Review Response

Project Name: Henry Pier Extension & Bulkhead Pier

Response To: SHL22-021 (Henry Pier Expansion)

# DETAILS- COVE

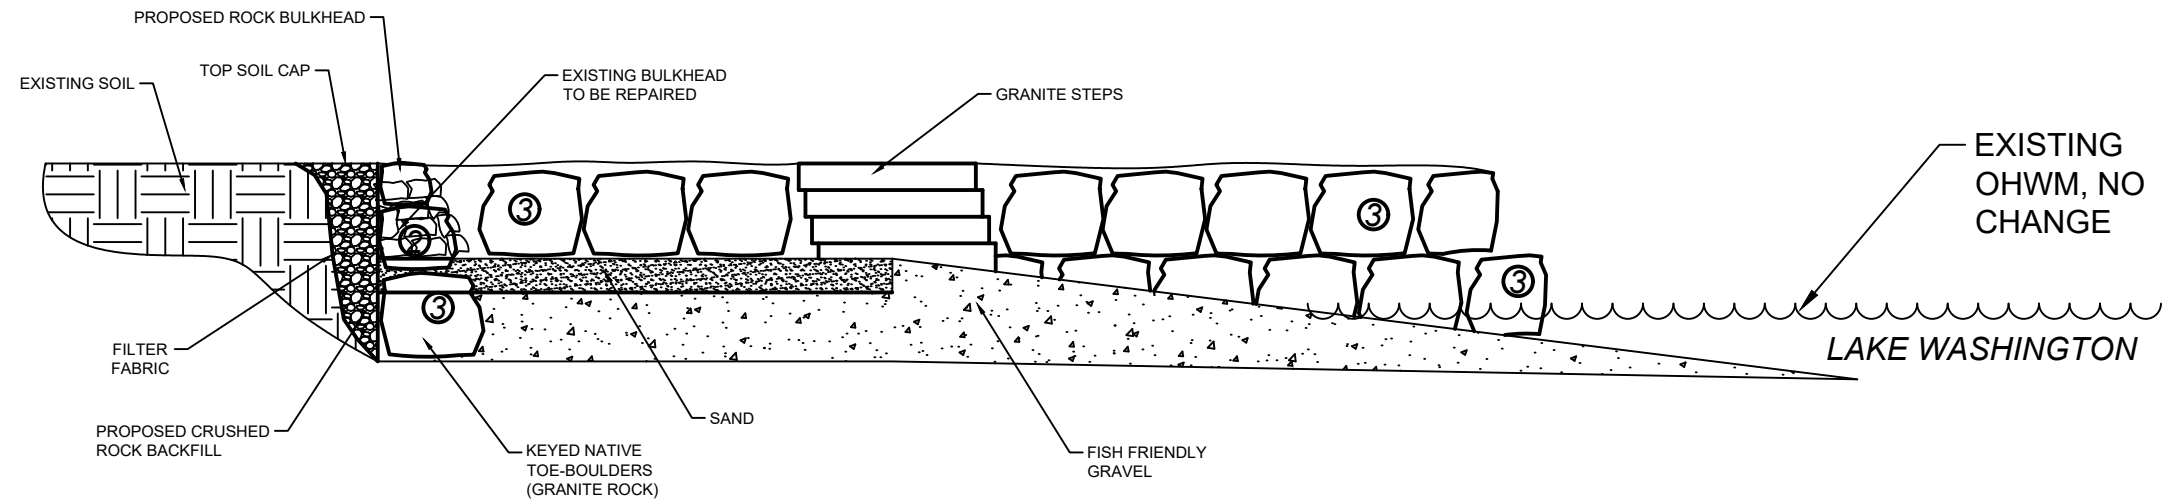
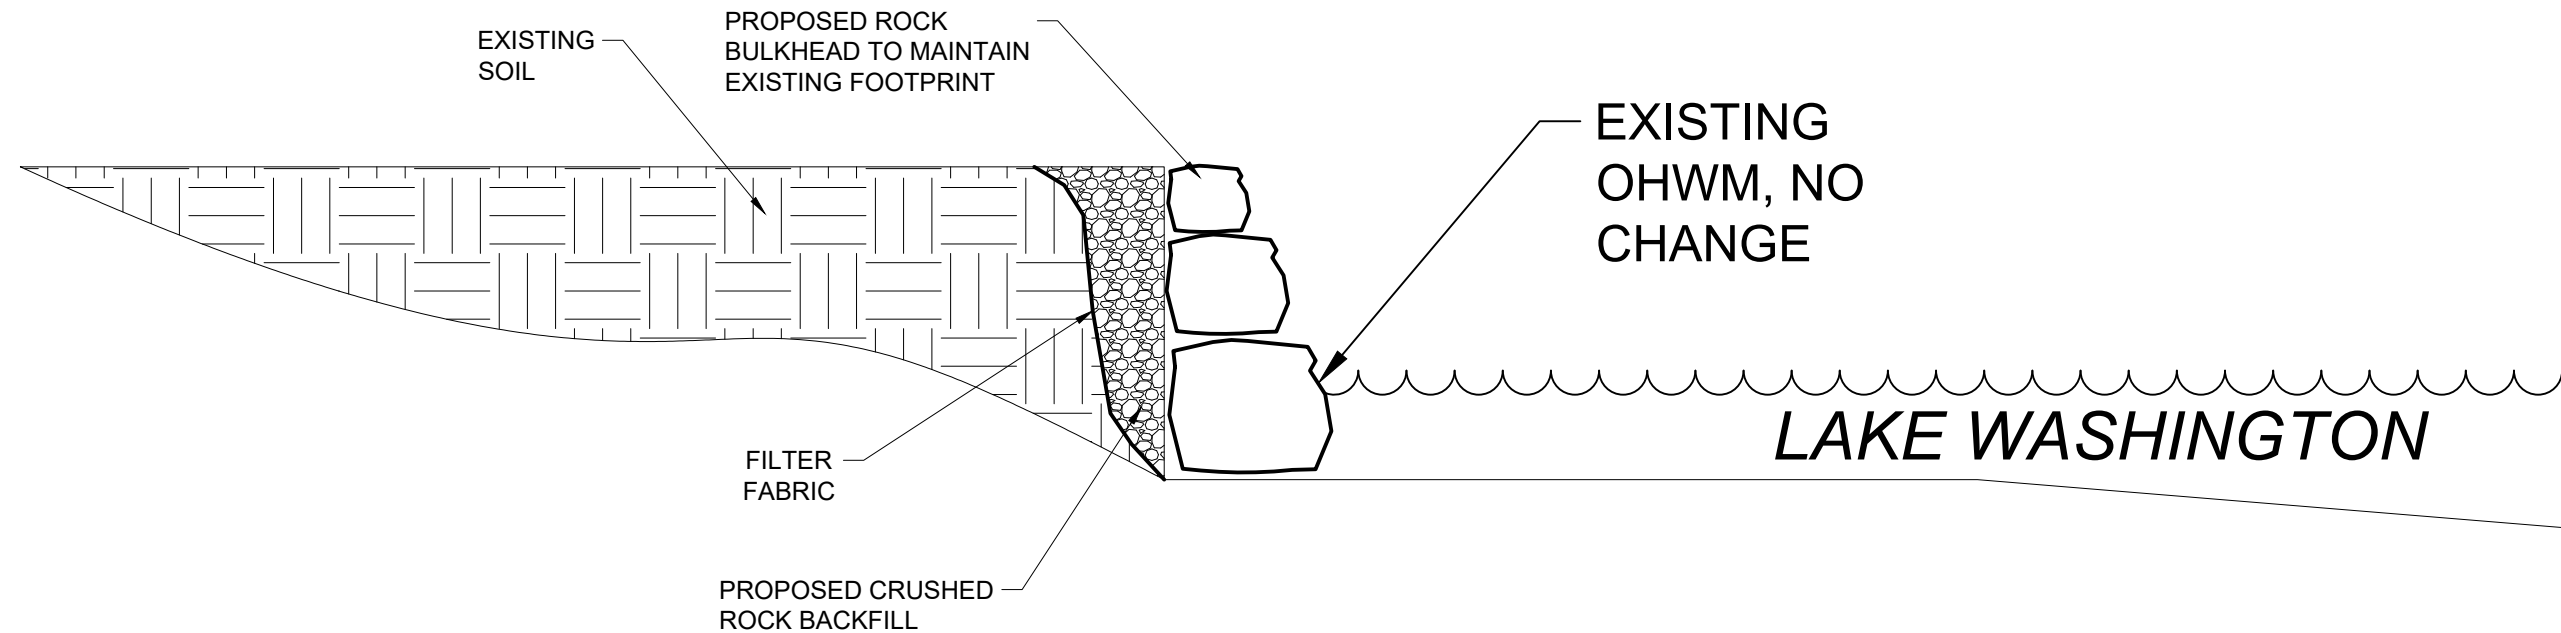
5. MICC 19.13.050(B)(1)(ii) states that replacement walls or bulkheads shall not encroach waterward of the existing structure unless the primary structure was occupied prior to January 1, 1992, and there are overriding safety or environmental concerns. Please show the location of the existing bulkhead on the bulkhead detail sheet to confirm whether the replacement bulkhead encroaches waterward of the existing bulkhead. If the replacement bulkhead encroaches waterward of the existing bulkhead, please provide documentation that there is a safety or environmental concern that requires further encroachment.

Replacement bulkhead will not encroach further waterward than existing bulkhead. A14 in plan set indicates that OHWM will remain in same location, as replacement bulkhead will be in same location as existing.

# EXISTING HARDSCAPE CALCULATION DRAWING

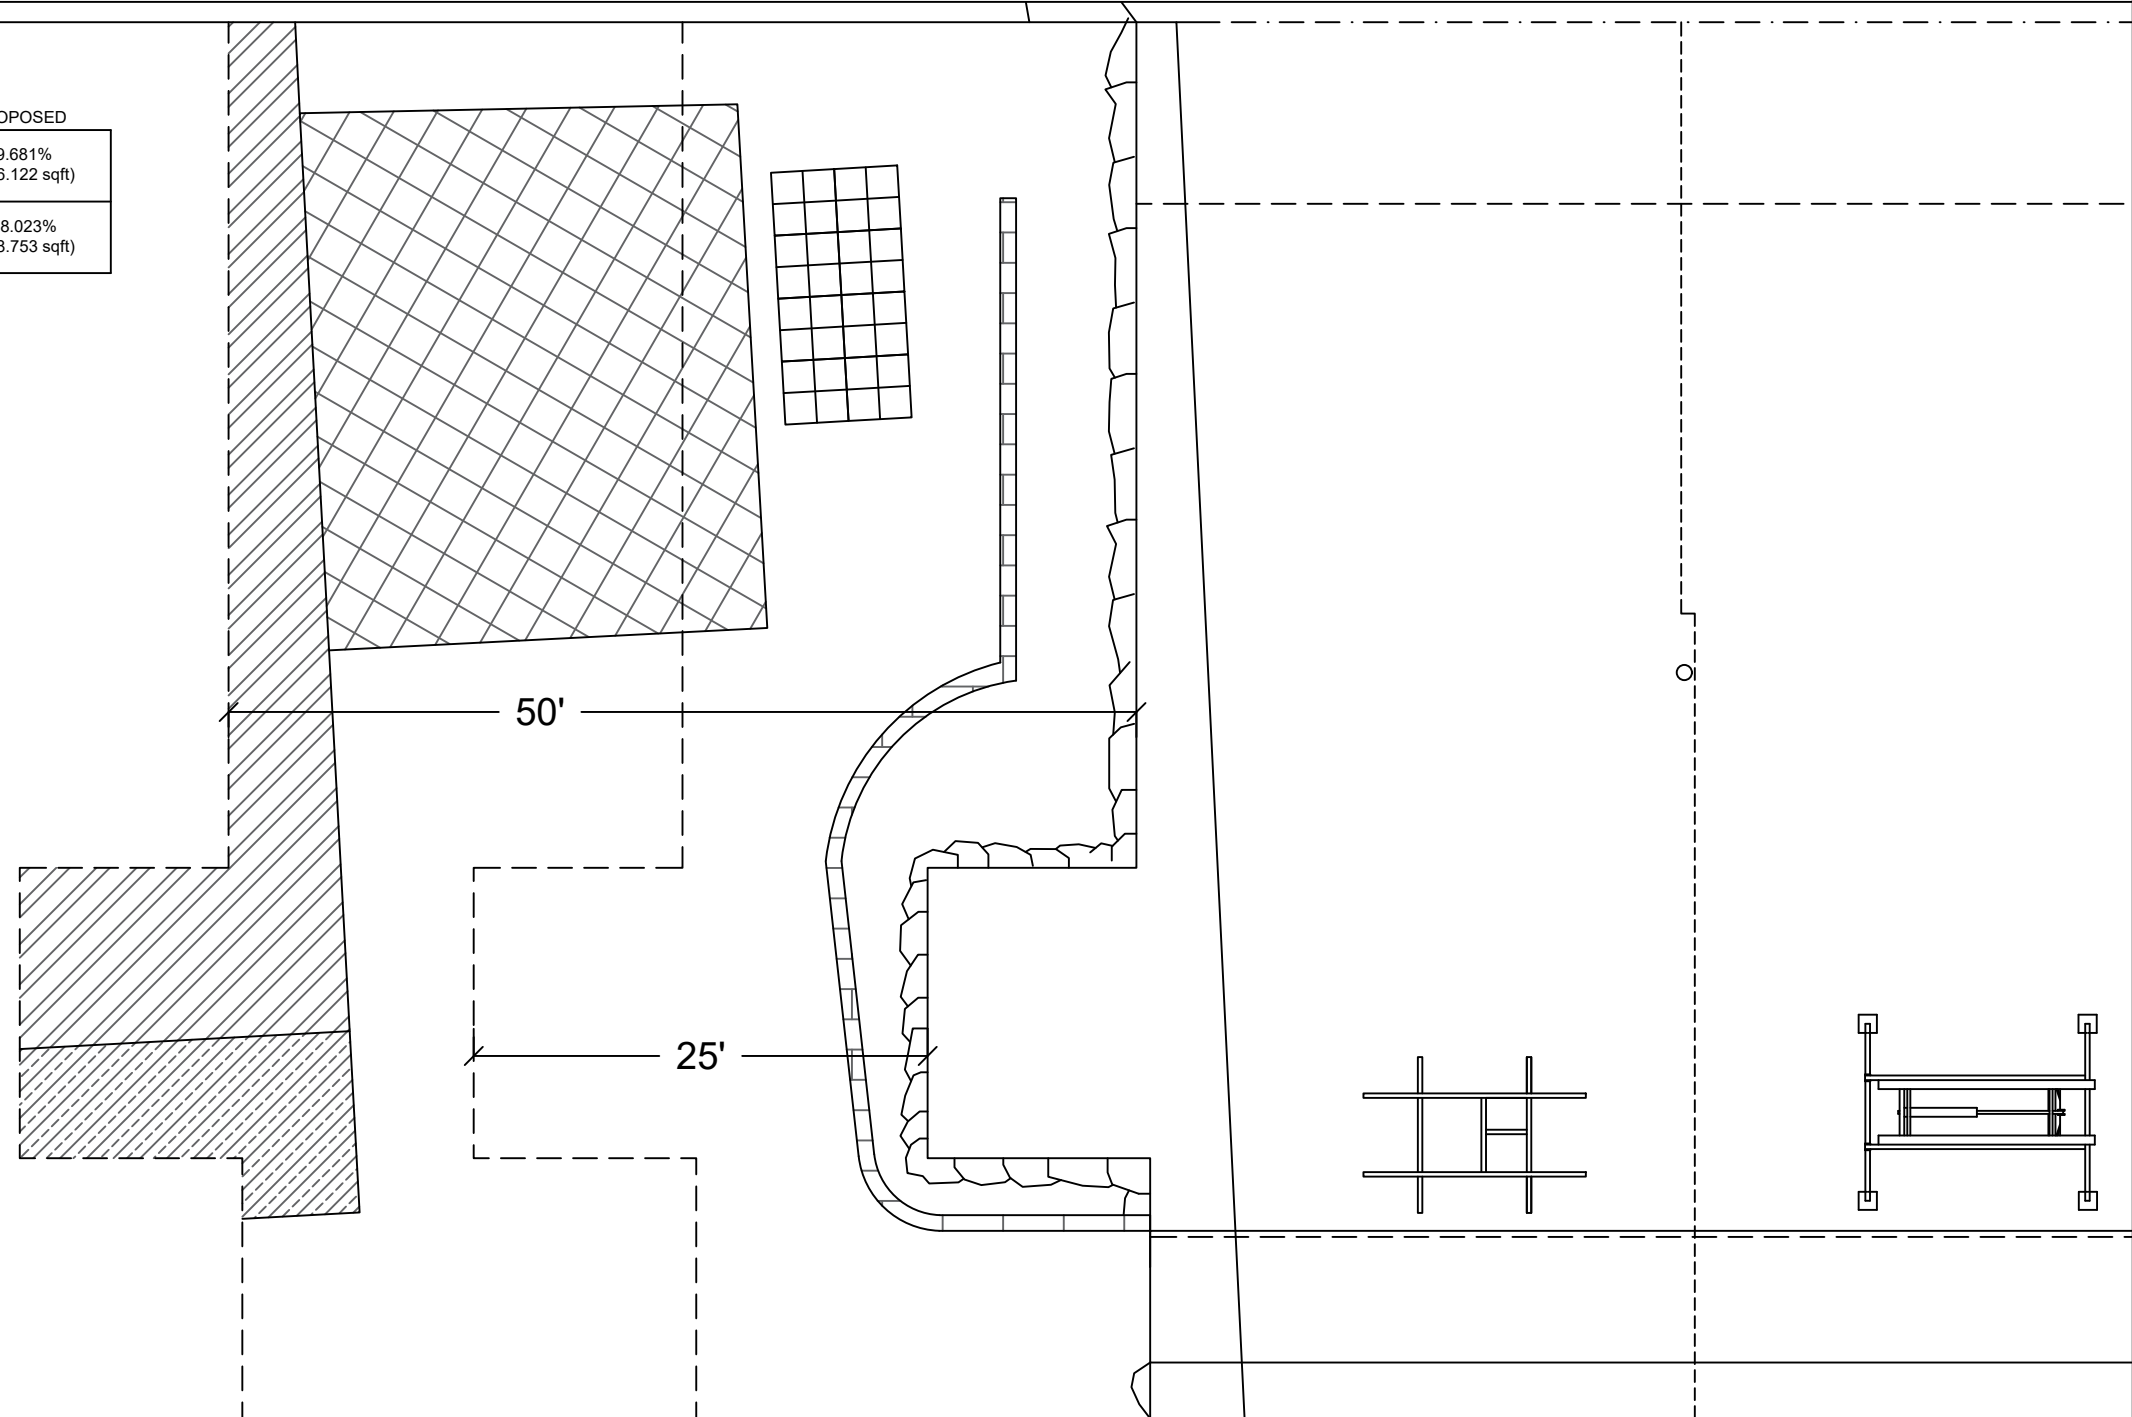
8. Please provide surface coverage (lot coverage and hardscape) calculations showing that the following standards are met:

- A maximum of 10% of the area between 0 and 25 feet landward of the OHWM may be covered by lot coverage and hardscape.
- A maximum of 30% of the area between 25 and 50 feet landward of the OHWM may be covered by lot coverage and hardscape.

See sheets A15 & A16 of revised plan set.
